09/04/2021

**St Marys Resource Recovery Facility (Borg) (SSD-10474)
Response to submissions**

Attachment 1

DRAWING
PROPOSED GROUND FLOOR PLAN

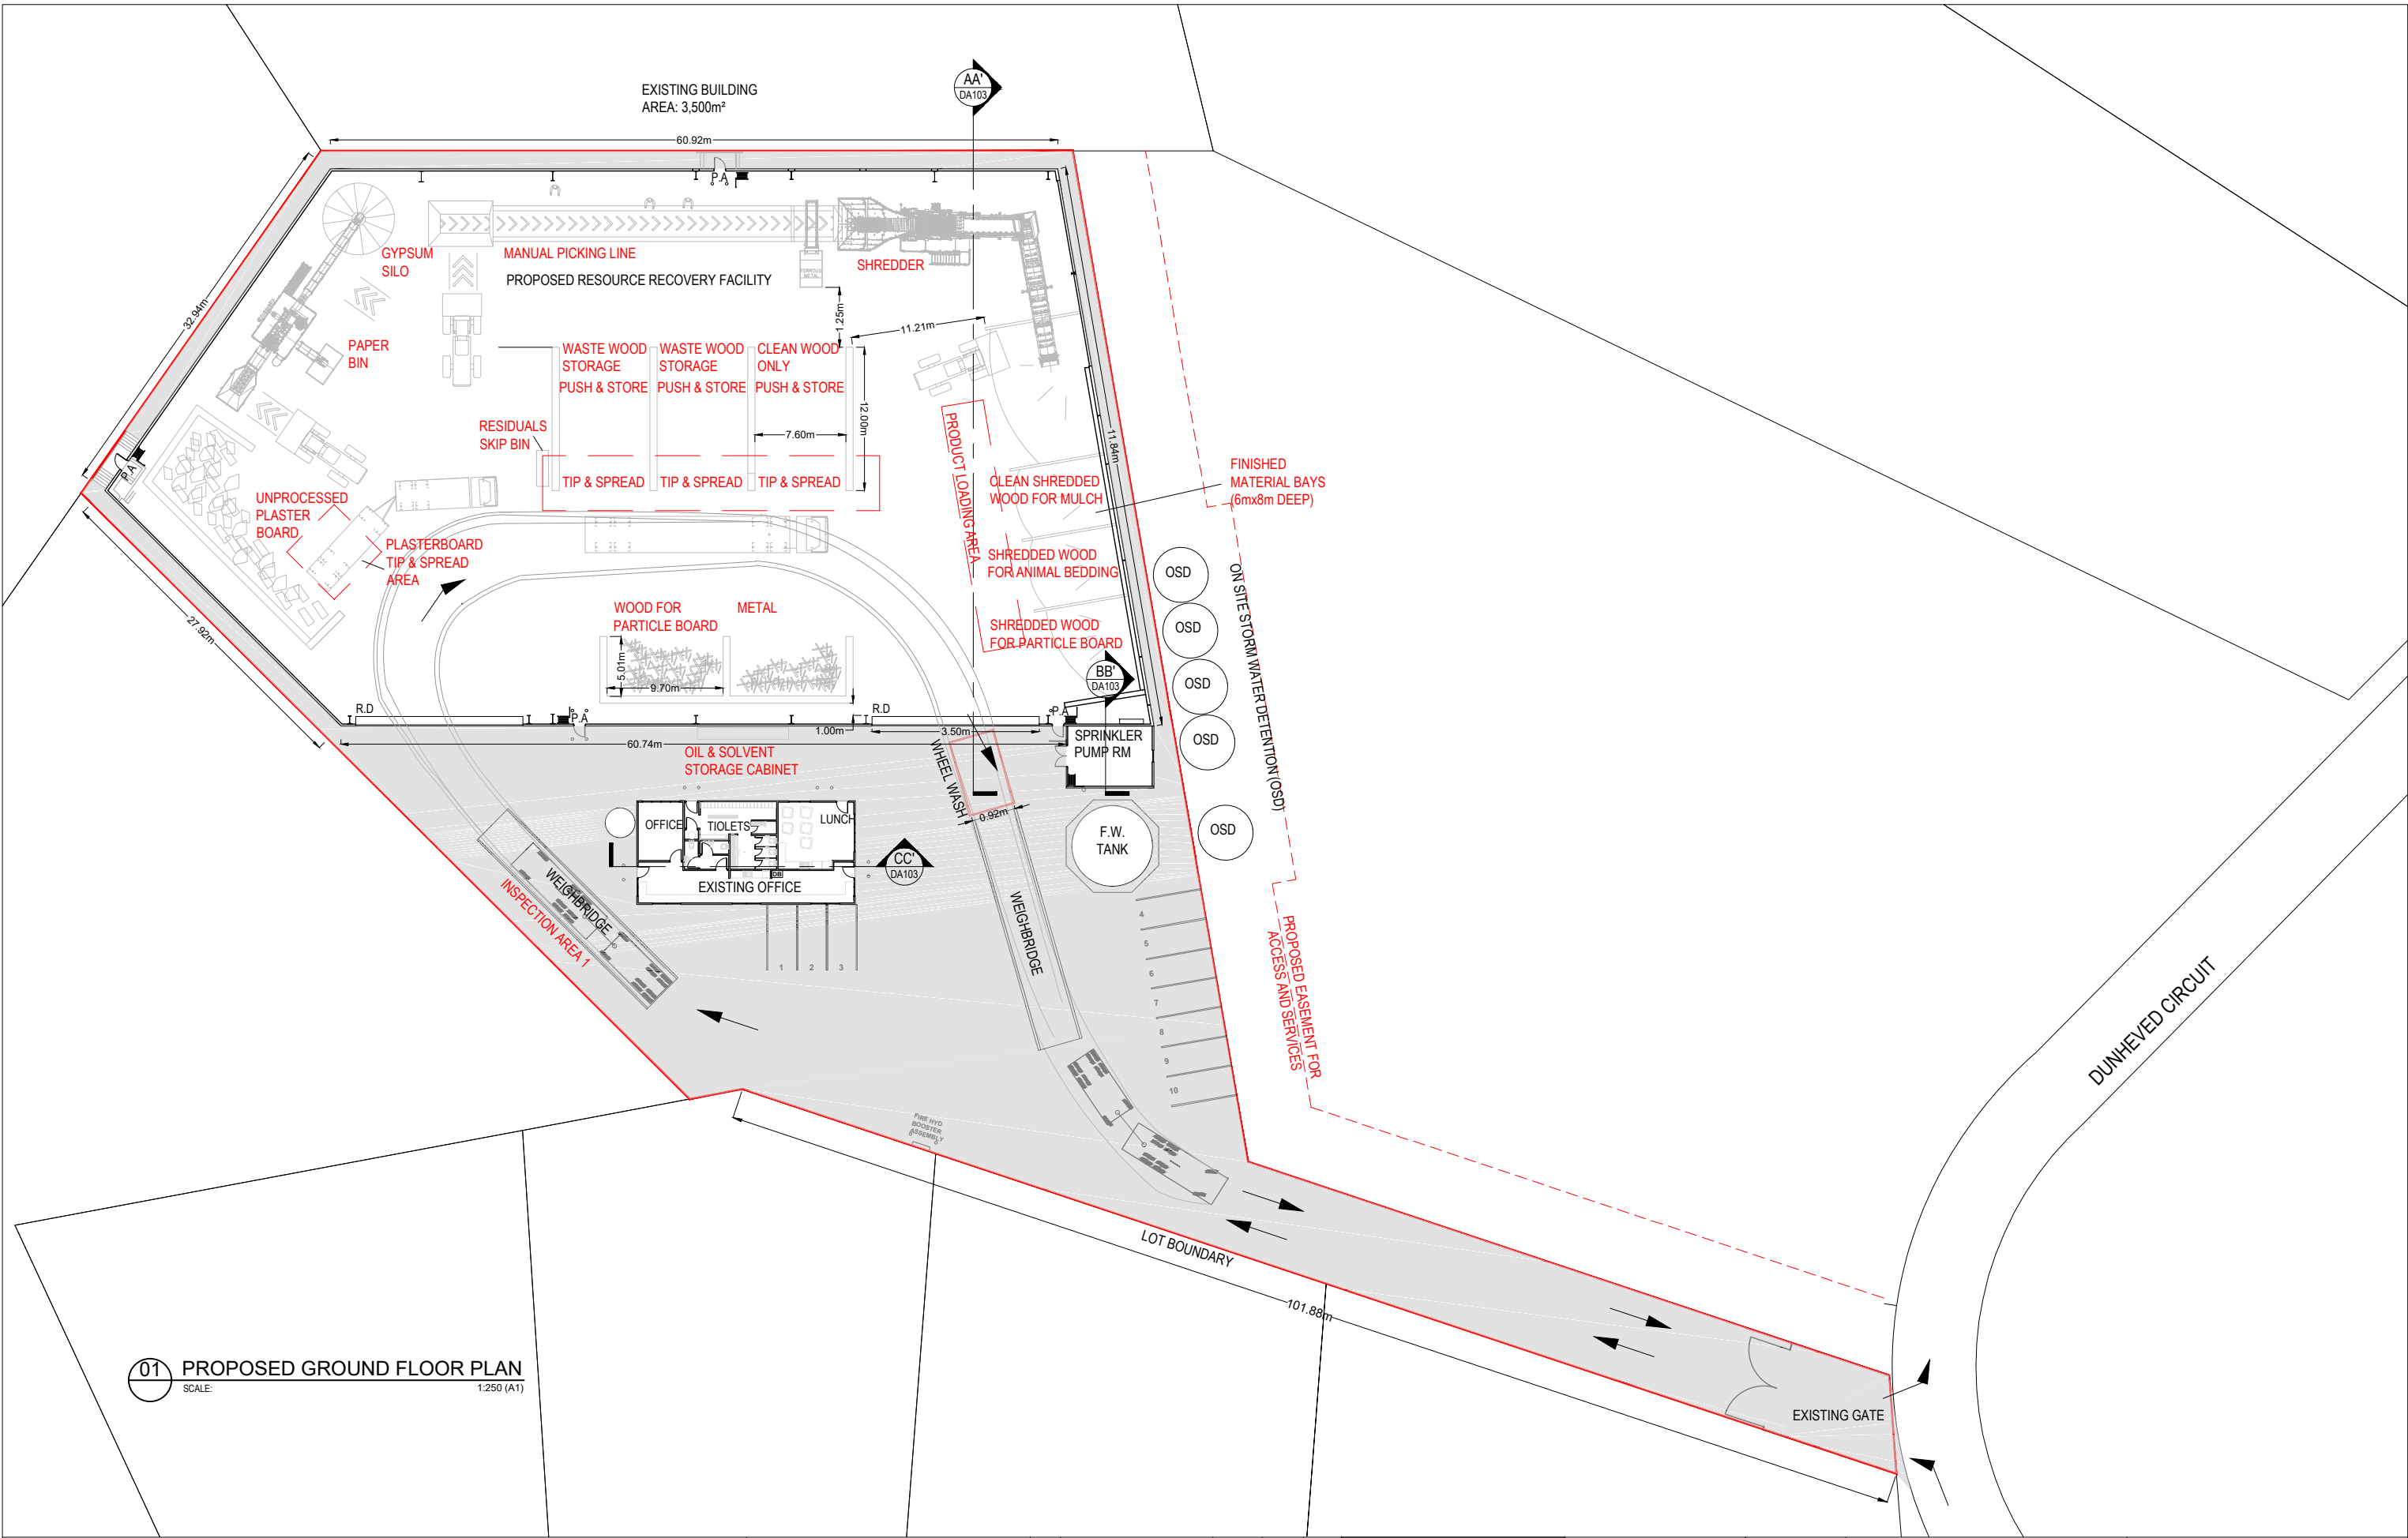
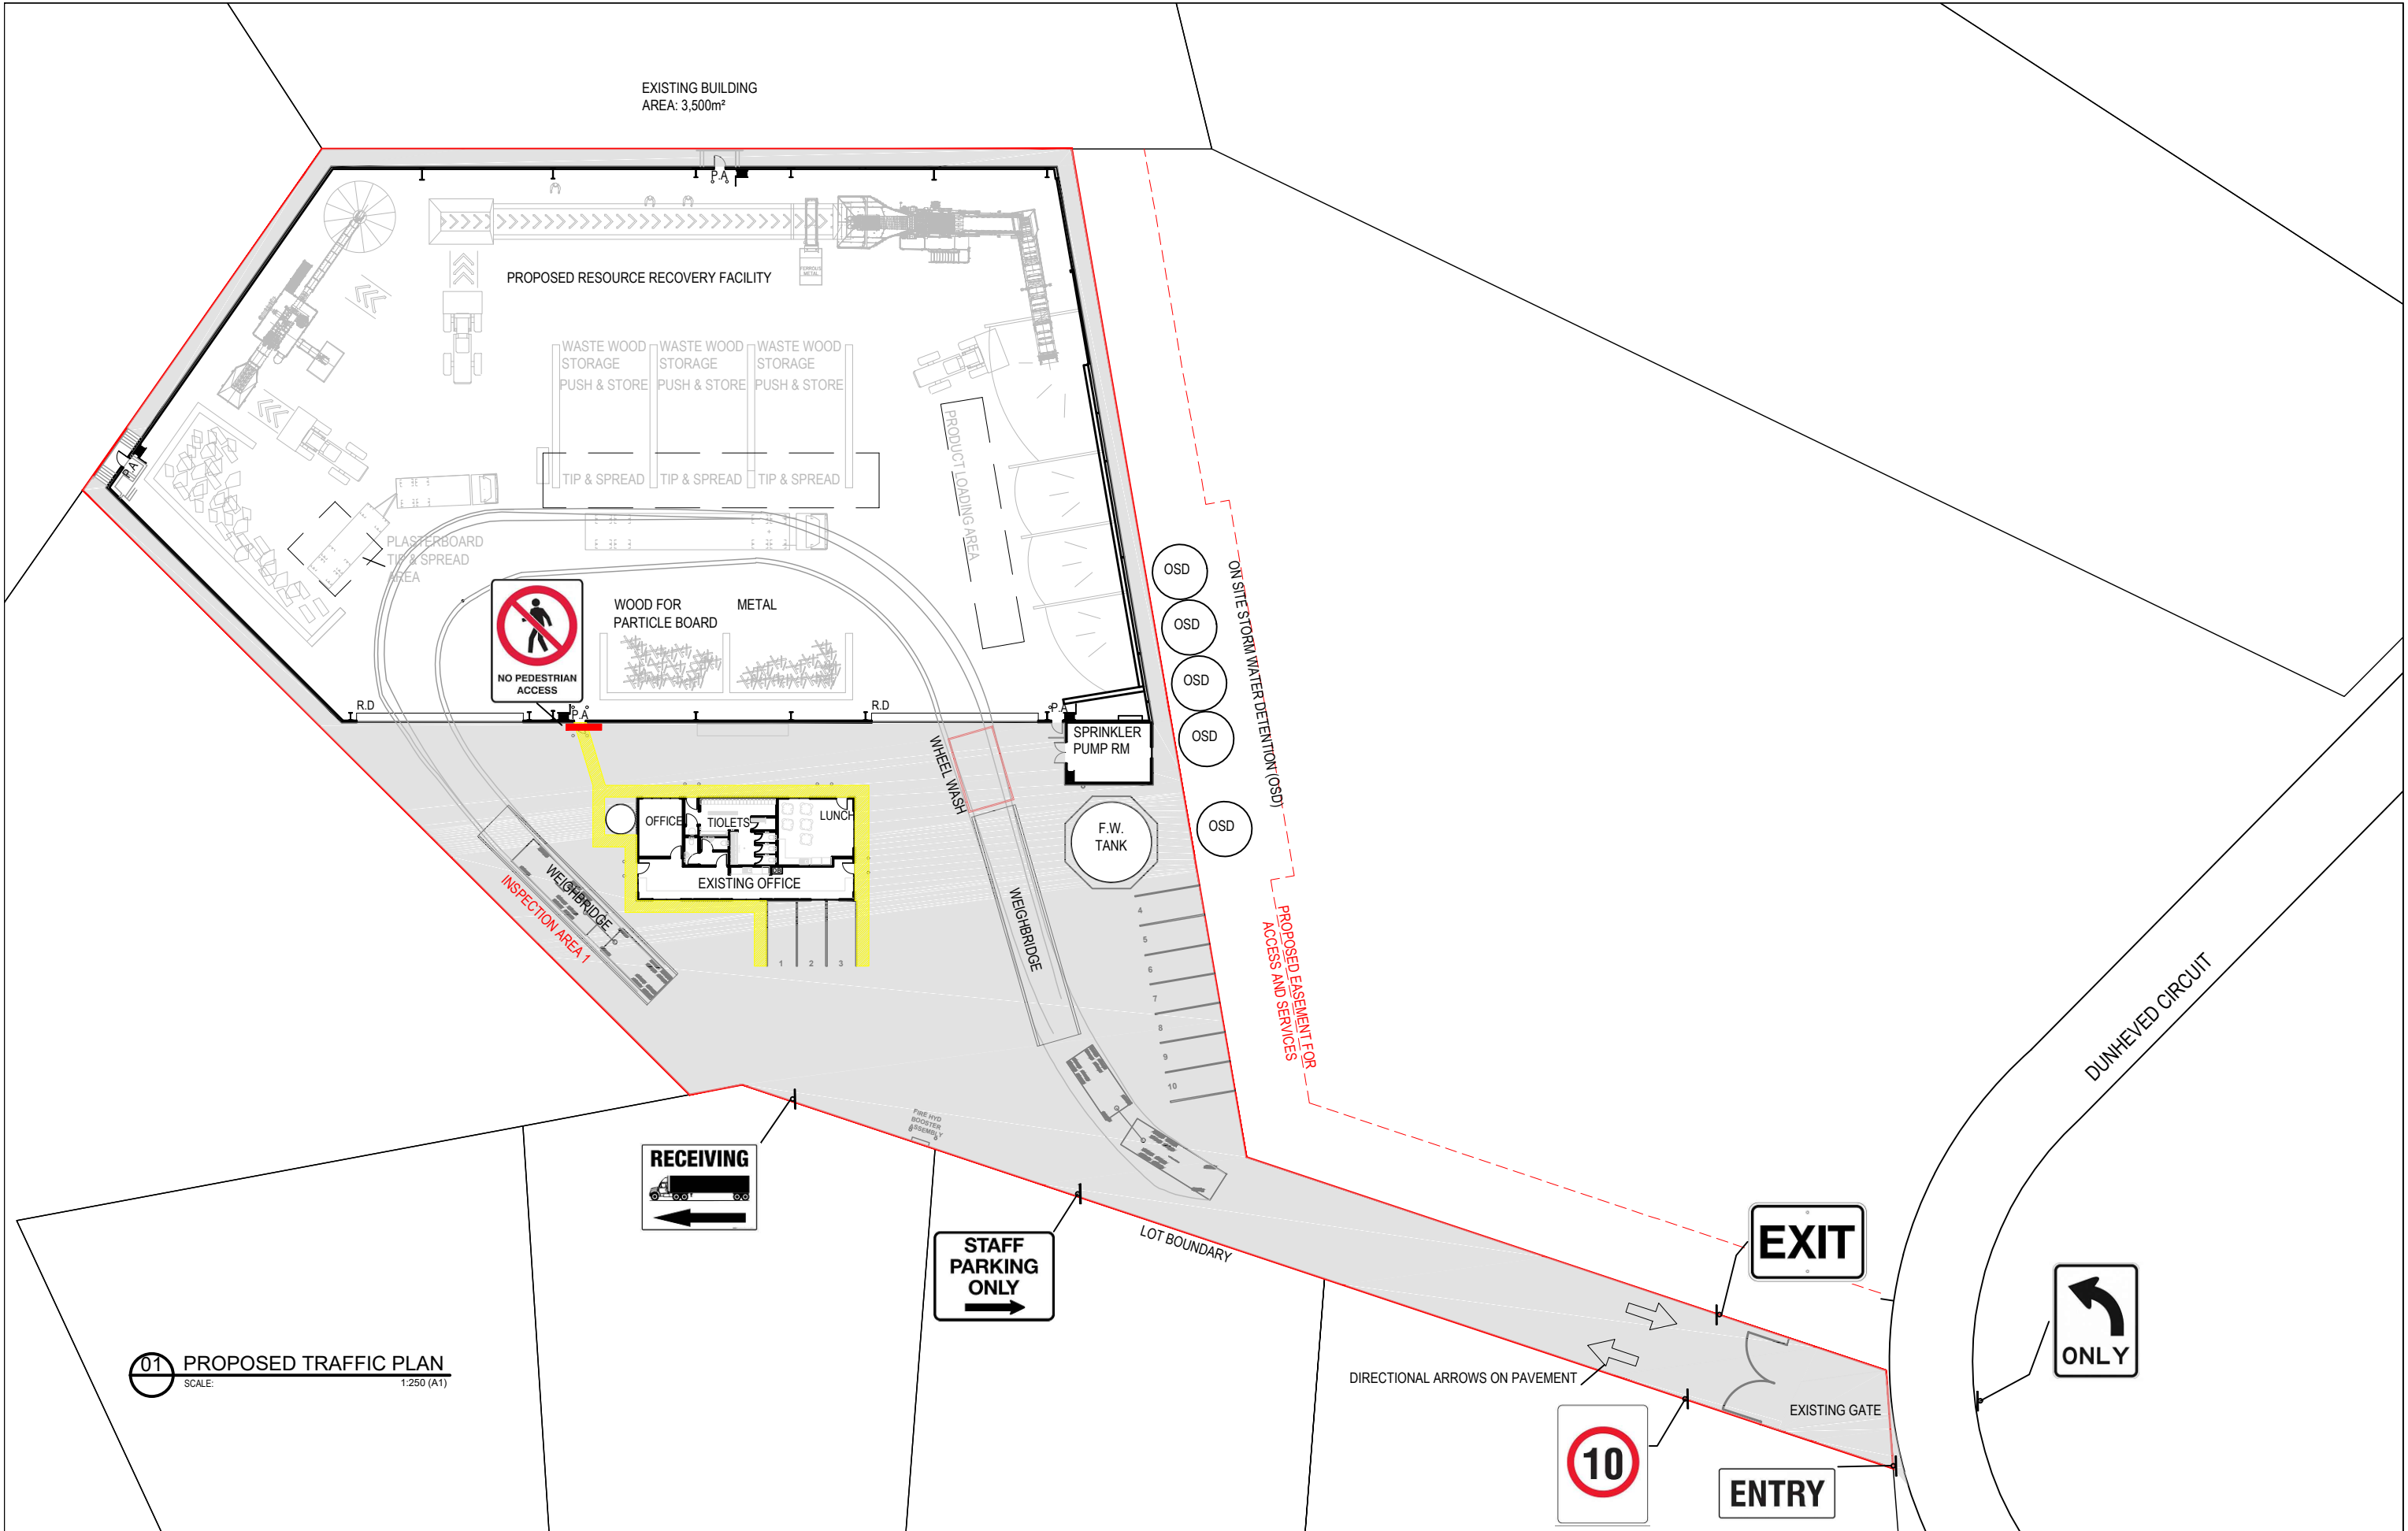
- The tip and spread area for the wood waste appears to overlap with the storage bays and truck manoeuvring area. Please clarify whether waste tipped in this area will impact on the storage capacity of these bays or impede truck movement through the building.
- Section 8.2.5 of the EIS identifies that the chemical storage cabinet will be located inside the warehouse, however, the cabinet appears to be shown outside the warehouse on the Proposed Ground Floor Plan (Drawing No. DA03).

PROJECT RESOURCE RECOVERY FACILITY		DRAWING PROPOSED TRAFFIC AND SIGNAGE PLAN	
LOCATION 25 DUNHEVED CIRCUIT ST MARYS		SCALE 1:250 @ A1, 1:500@A3	STAGE DA
PROJECT NUMBER 2020/01	DRAWING NUMBER DA04	ISSUE D

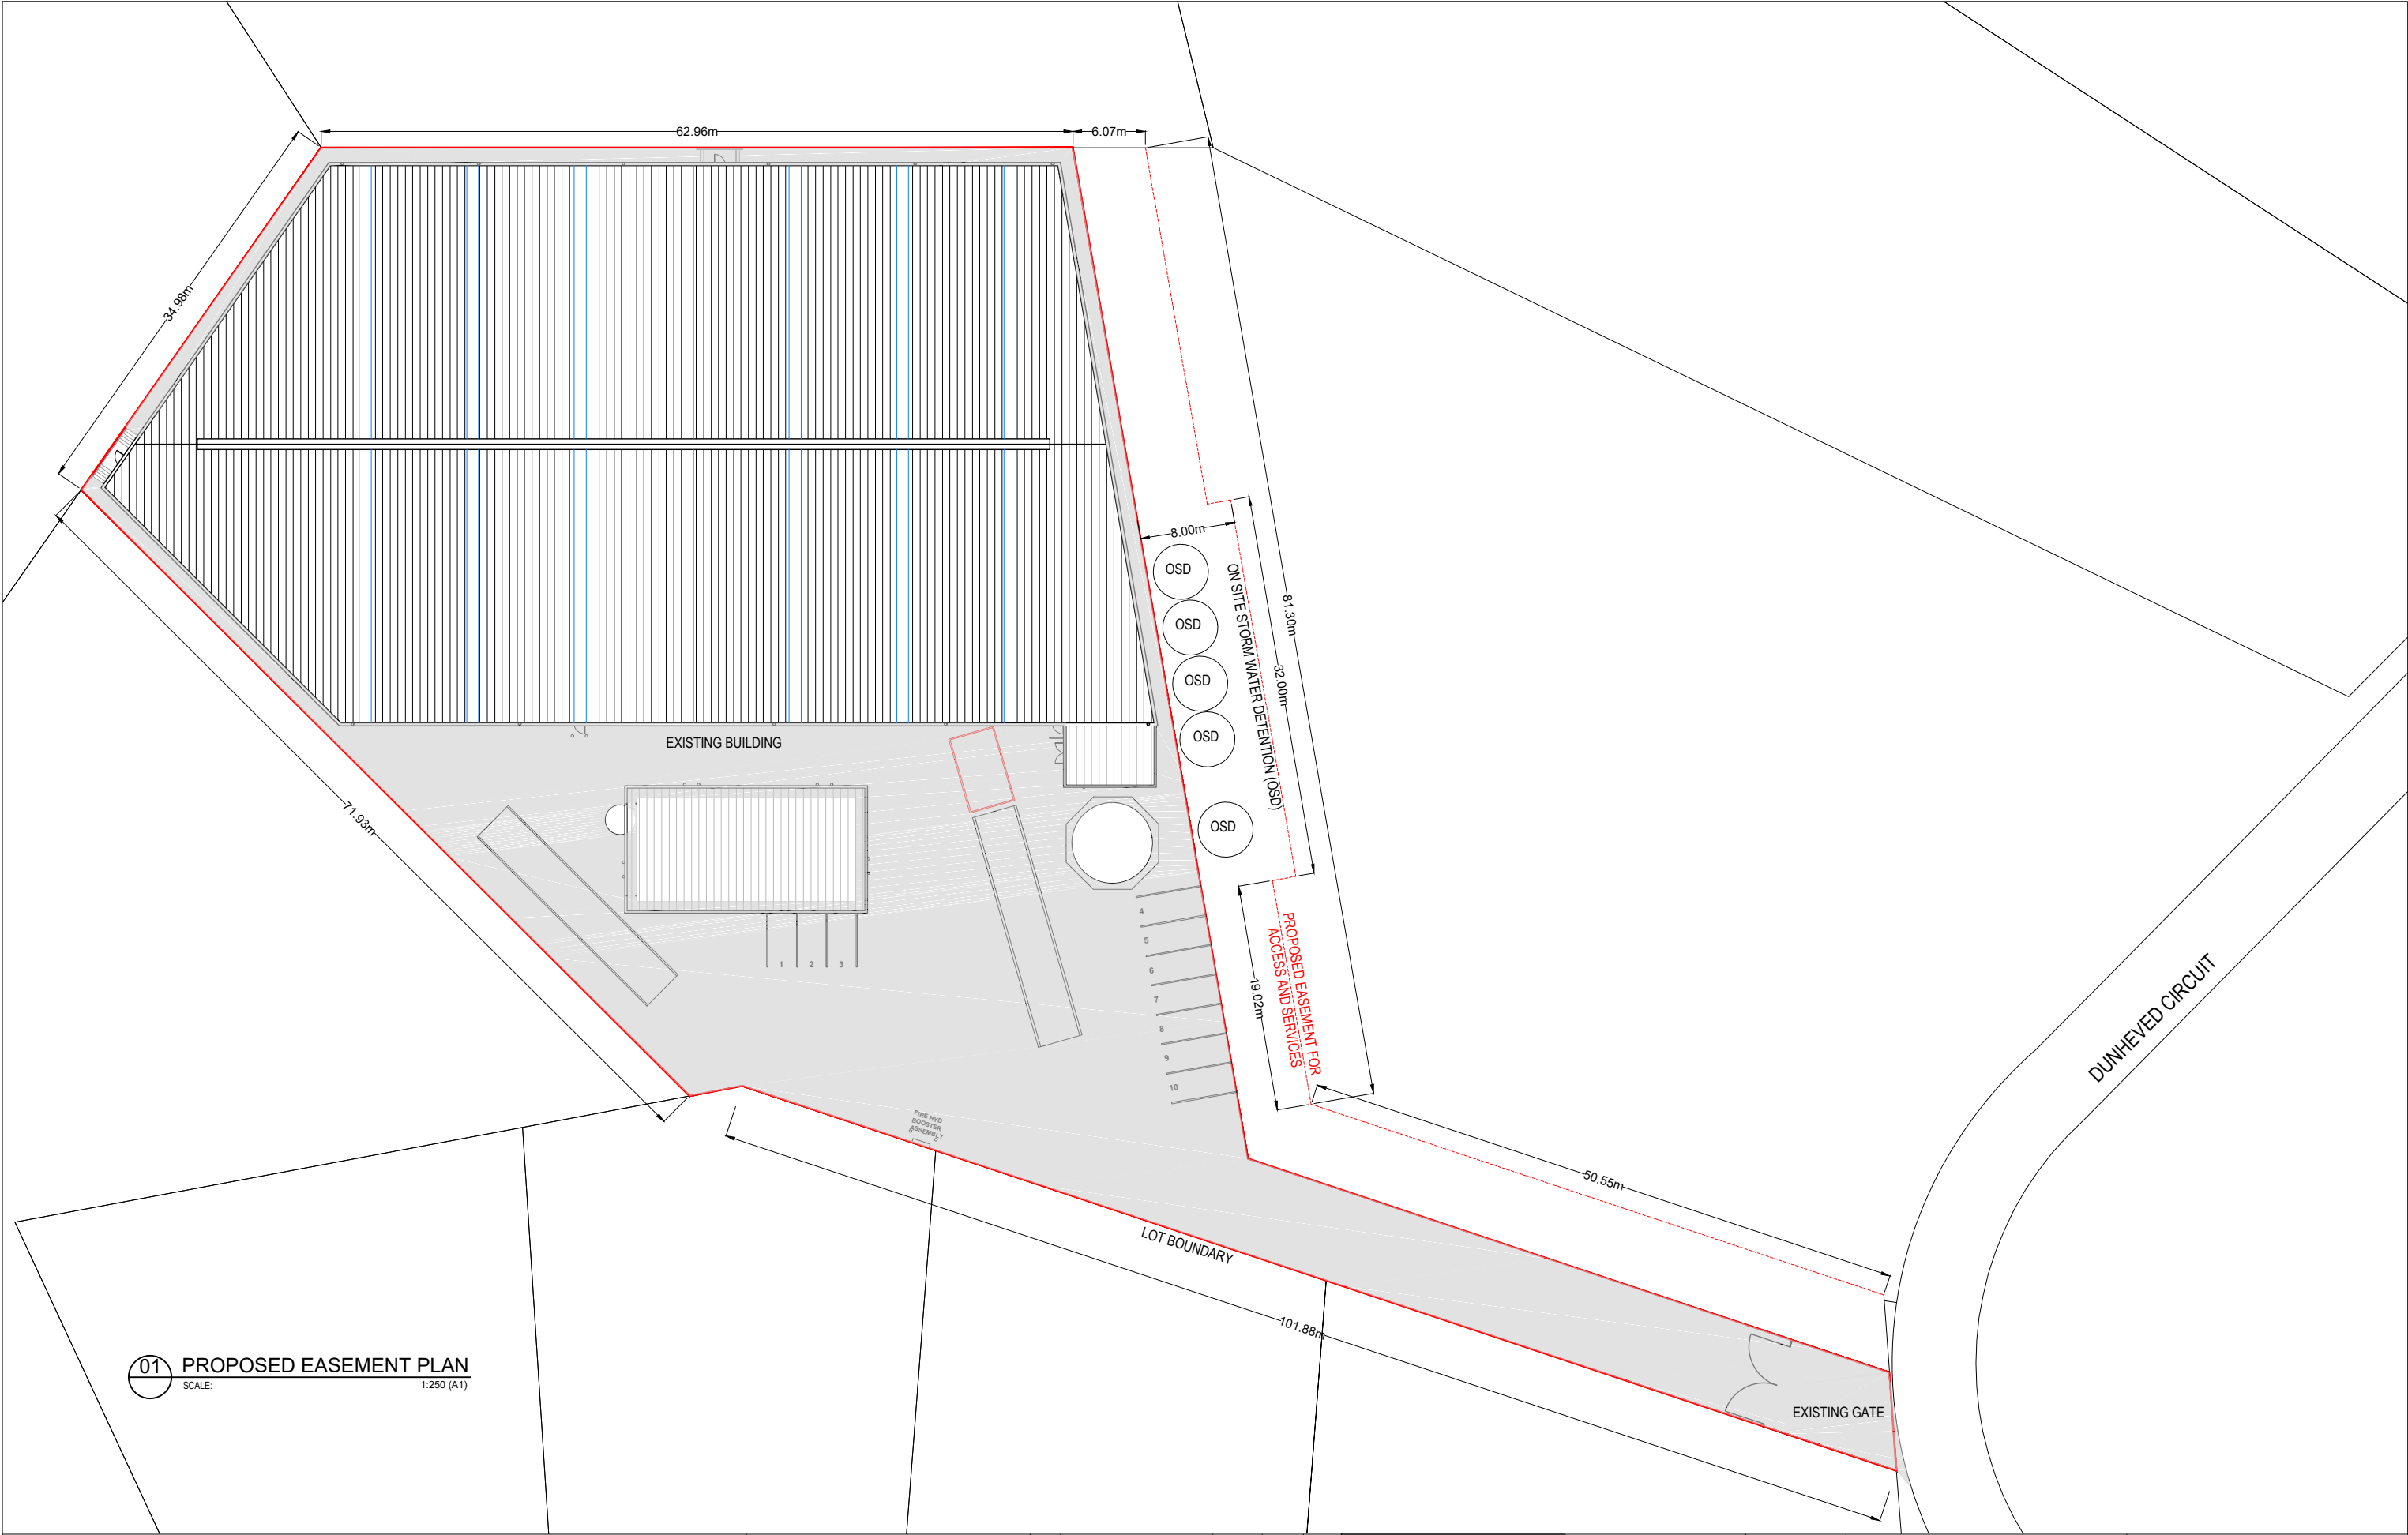
- It is noted that the TIA states that no visitor or accessible parking spaces will be provided (page 31), but one visitor and one accessible space is shown on the Proposed Traffic and Signage Plan (Drawing No DA04). Please clarify whether these spaces will be provided.
